Subject: RE: Planning Consultation on: P/146/21/DOC

Engineers Comments Regarding Surface Water Drainage

Application No: P/146/21/DOC
Registered: 18th October 2021
Site Address: Little Sefter Farm Pagham Road Pagham
Description of Works: Approval of details reserved by condition imposed under P/38/21/PL relating to conditions 2-surface water drainage scheme, 4-Landscape & Ecology Maintenance Plan & 5-landscape scheme.

PROJECT	BARN EXTENSION BARFOOTS - LITTLE SEFTER PAGHAM RD, BOGNOR REGIS W SUSSEX, PO20 1LN			
	PROPOSED SW DRAINAGE LAYOUT			
DRAWING	FC2846/02			
	REV C			
SCALE	1:125			
	DATE	JAN 20	MH	CHKD -

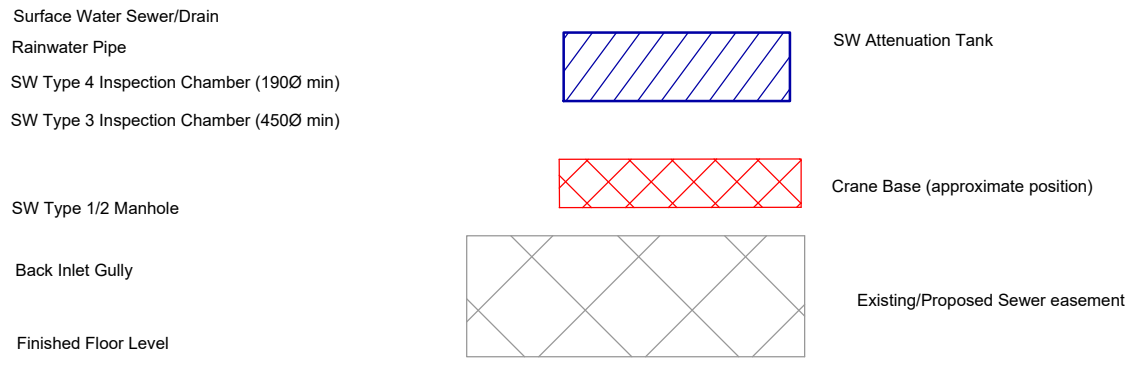
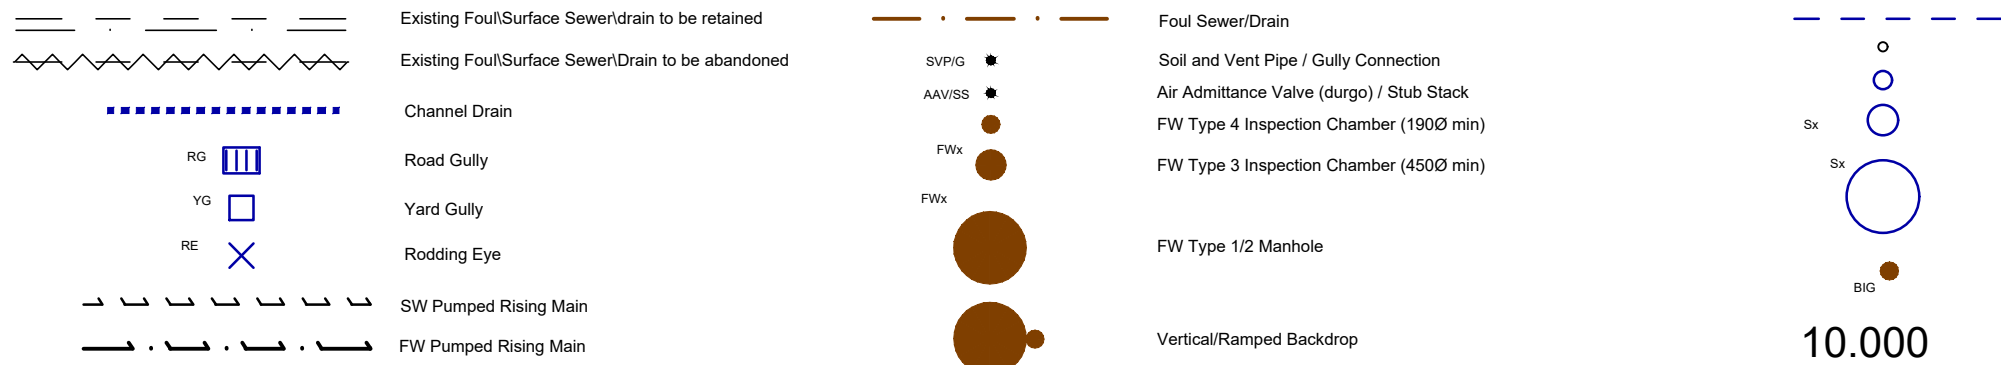
2. On the Drainage Layout there is a 'Note the following' The second note relating to the Hydrobrake needs to be adjusted for the new Hydrobrake limiting flow to 2l/s. – Noted and Updated

3. Please add a note that all pipe junctions (not connected via manholes) need to utilise oblique junctions.
Noted and Updated
4. Please include the width of the base and the width of the top of the pond (in the absence of a site specific cross sectional drawing or a setting out drawing) on the drainage layout. Noted and Updated

SHE-0076-2000-0400-2000
 Hydro-Brake® Optimum

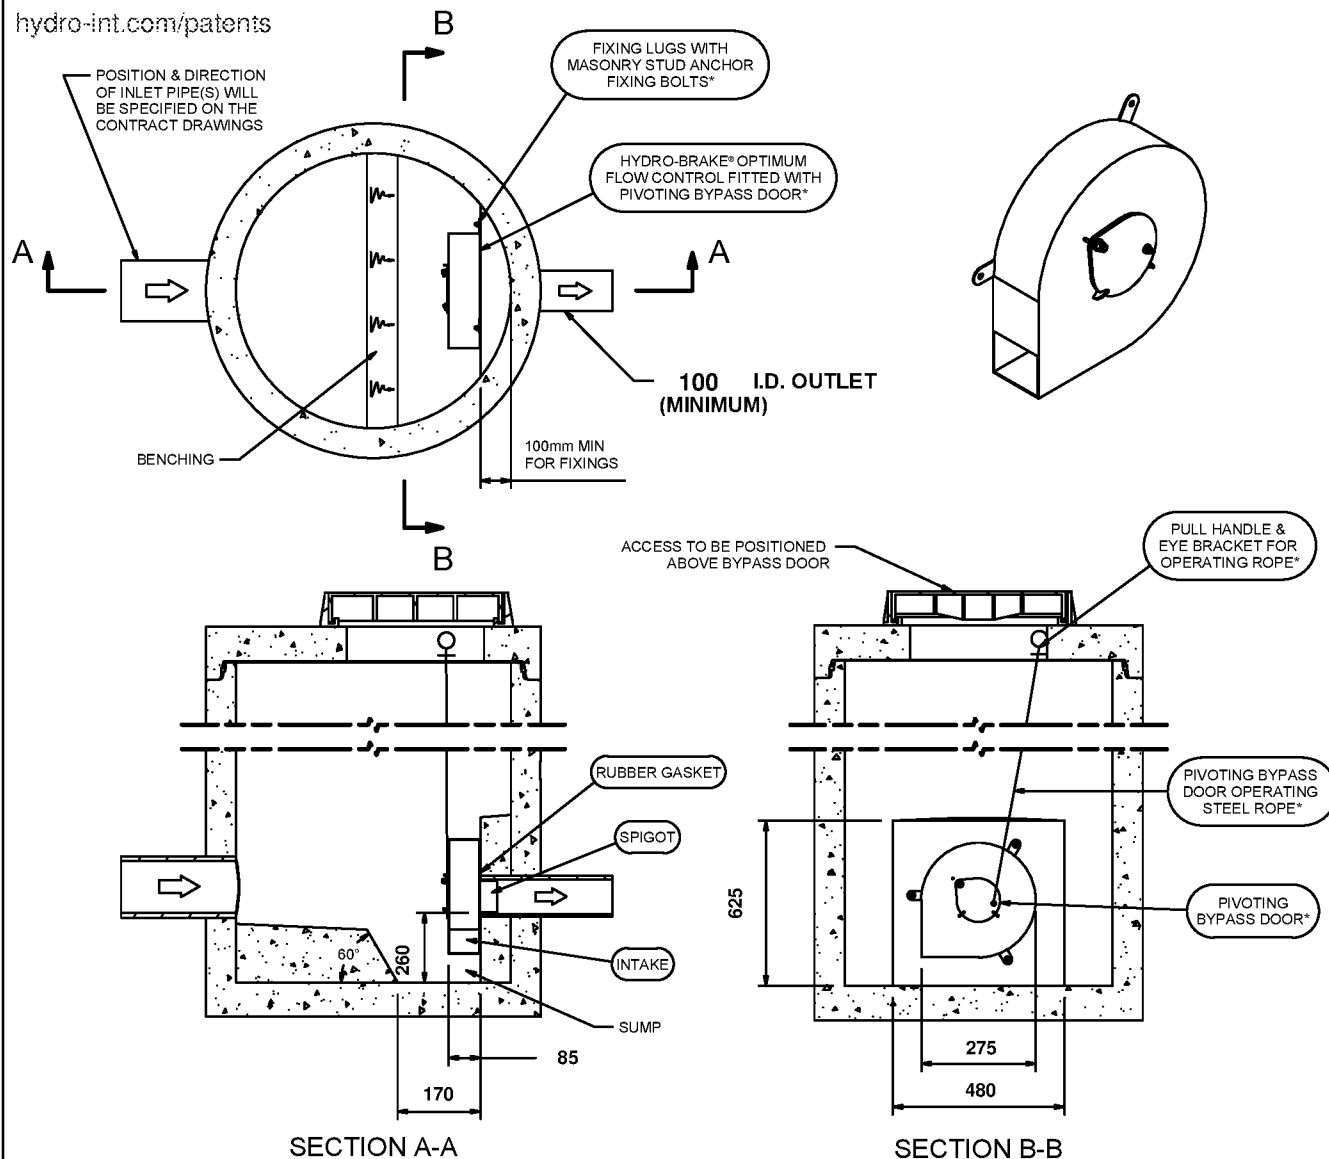
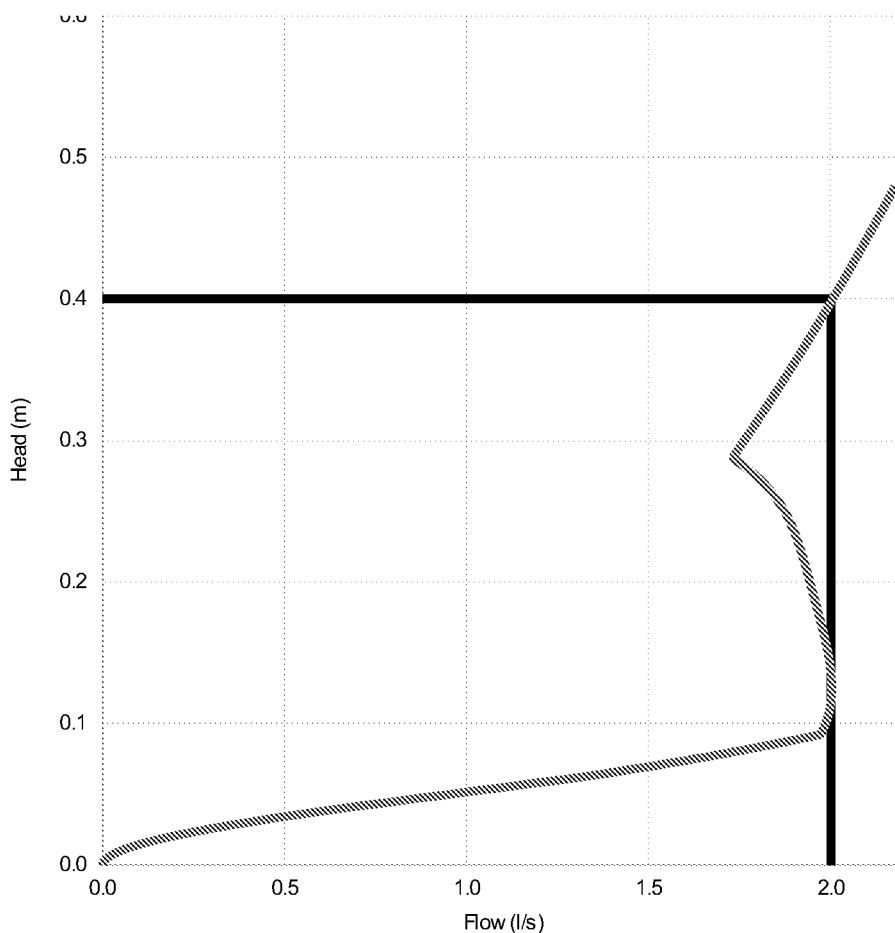
7. Please provide a site specific Hydrobrake detail. Please reference the Hydrobrake on the detail drawing and include the following: Noted and Updated
 - a) Invert level and cover level.
 - b) Incoming and outgoing pipe diameters.
 - c) No dimensions should be ‘tbc’ – please clarify.

Drawing No.
S278/38/25

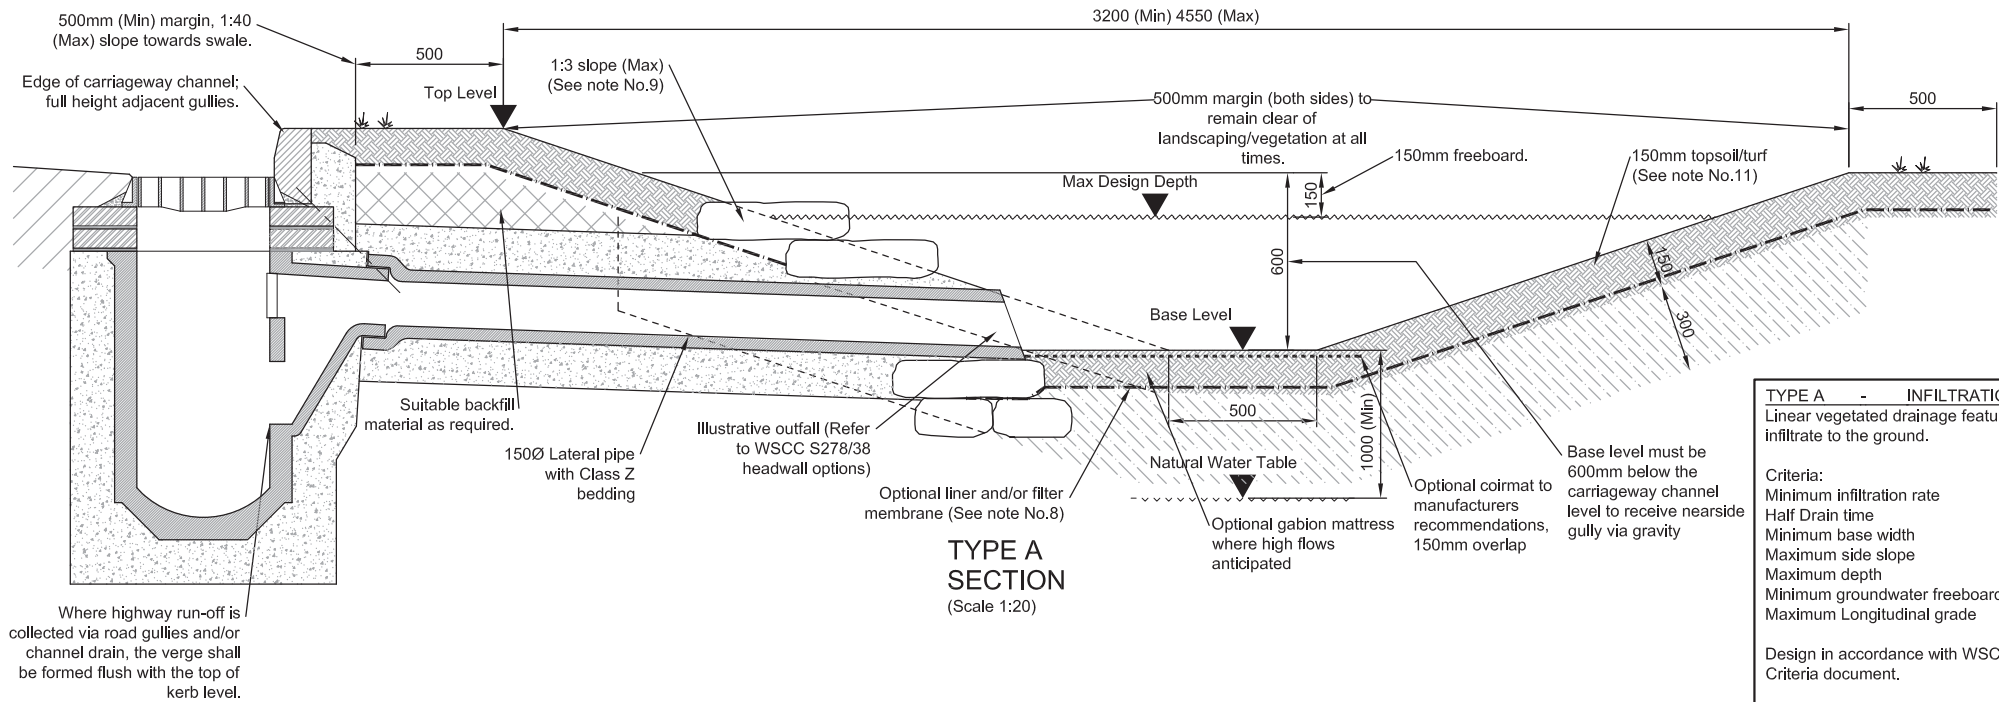
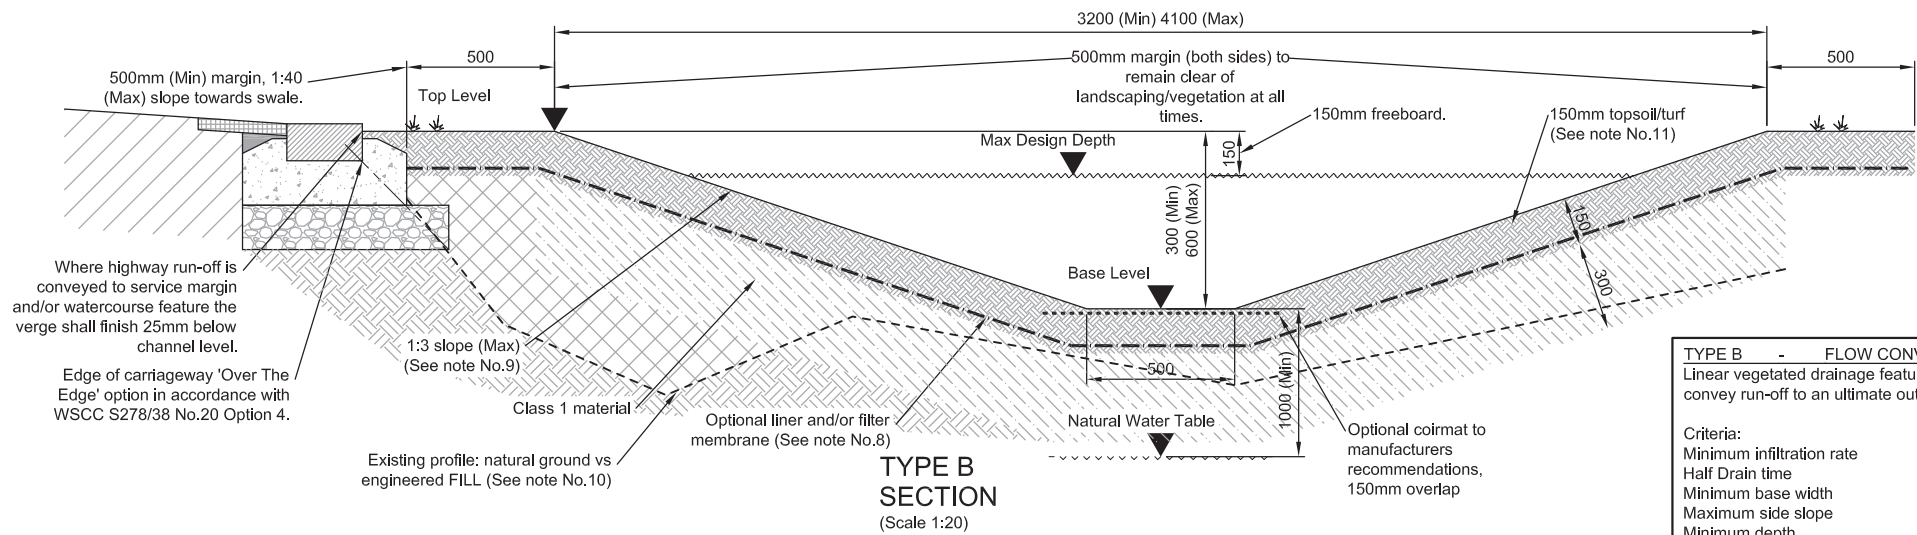
5. Dependant upon the response to point 1 further detail may be required regarding the membrane for the pond (permeable/impermeable) and possible floatation mitigation.

The storage feature is proposed to be constructed in accordance with WSCC S278/38/26 A Drainage Highway Swale detail. The detail highlights an optional liner and or filter membrane (see note No 8) – which states – ‘*Lining/membranes will be required if location in area of high pollution risk or risk of contamination.*’ Given this location is clearly not affected by these factors, no liner or filter membrane is proposed.

In addition, with ground water 2mBGL then floatation is not an issue. Given the proximity of the watercourse, the water level within the watercourse probably represents the adjacent GWL most accurately.

Providing no liner/membrane will enable the first flush of water entering the storage feature to be absorbed/infiltrate into the soil – providing a more SuDs like feature
